18 May 2016

Cameron Sargent
Team Leader, Key Sites Assessments
NSW Planning and Environment
23-33 Bridge Street,
SYDNEY NSW 2000

RE: SSD 6960 – Barangaroo South Stage 1B Basement

Figure 6: Typical basement car park level - B1 (Source: EIS)

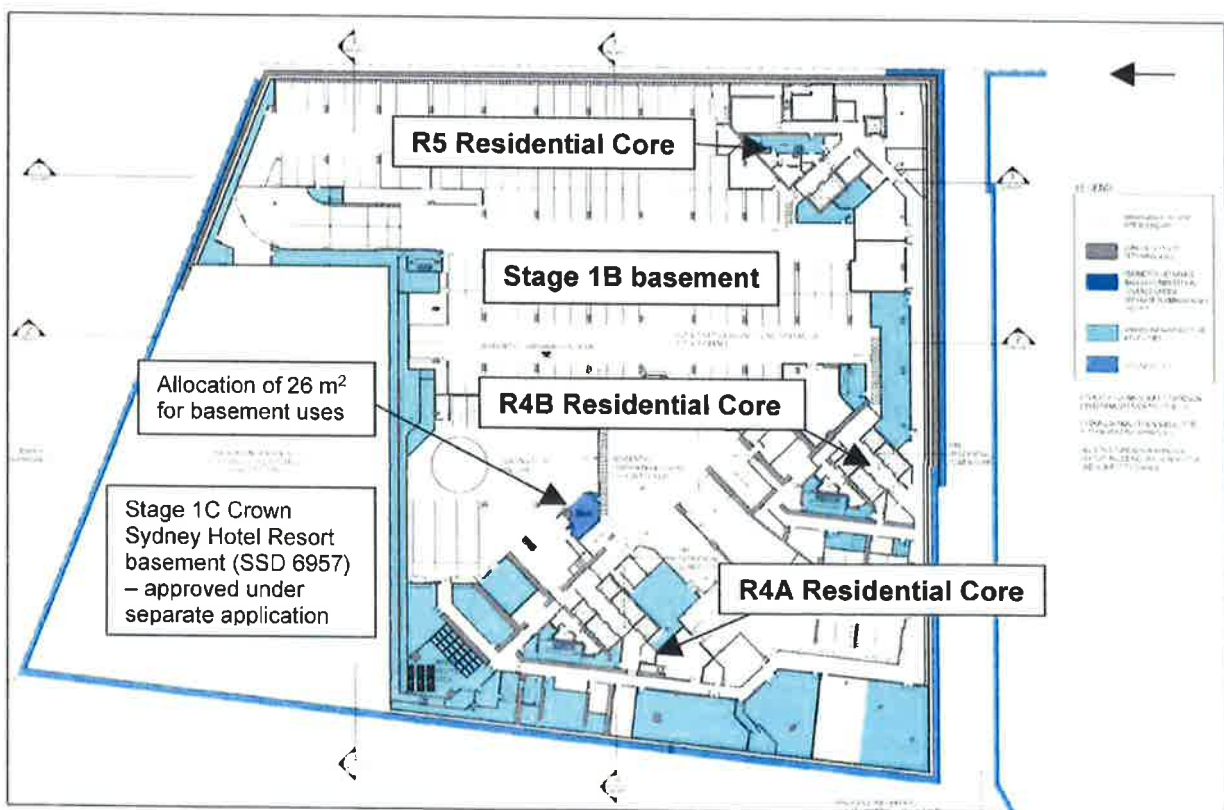
Bicycle parking is not discussed in the submitted TMAP and the architectural plans do not show bike park spaces or end of trip facilities. A "typical basement layout" plan indicates bike parking dispersed through the level. All bike parking and end of trip facilities should be provided at upper basement levels and grouped together. Bike parking rates and end of trip facility provision should be based on the requirements of Sydney DCP 2012.

Figure 12: Interim public domain plan including vehicular access (Source: EIS)

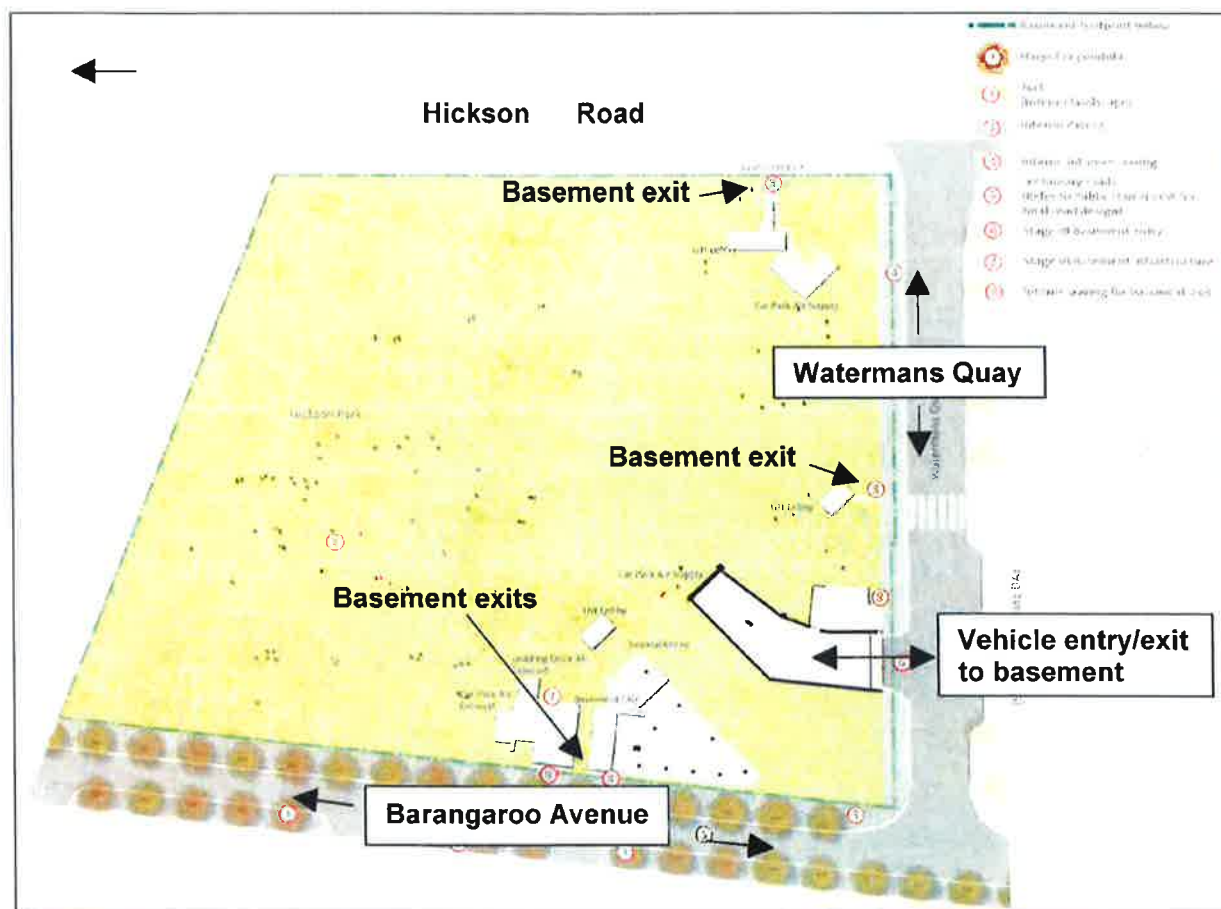
The drawings submitted identify a discontinuous footpath on the eastern side of Barangaroo Avenue, just west of the car park, substation and services risers. The footpath should continue by shifting the protruding cores to the east or reconfiguring the road.

Barton Street has no provision for footways in the submitted documentation. The application appears to be delivering only a portion of the road and clarification on the final alignment and width of the street should be provided. As a minimum at this unknown stage, pedestrian access must be provided around the perimeter of the park including Barton Street.
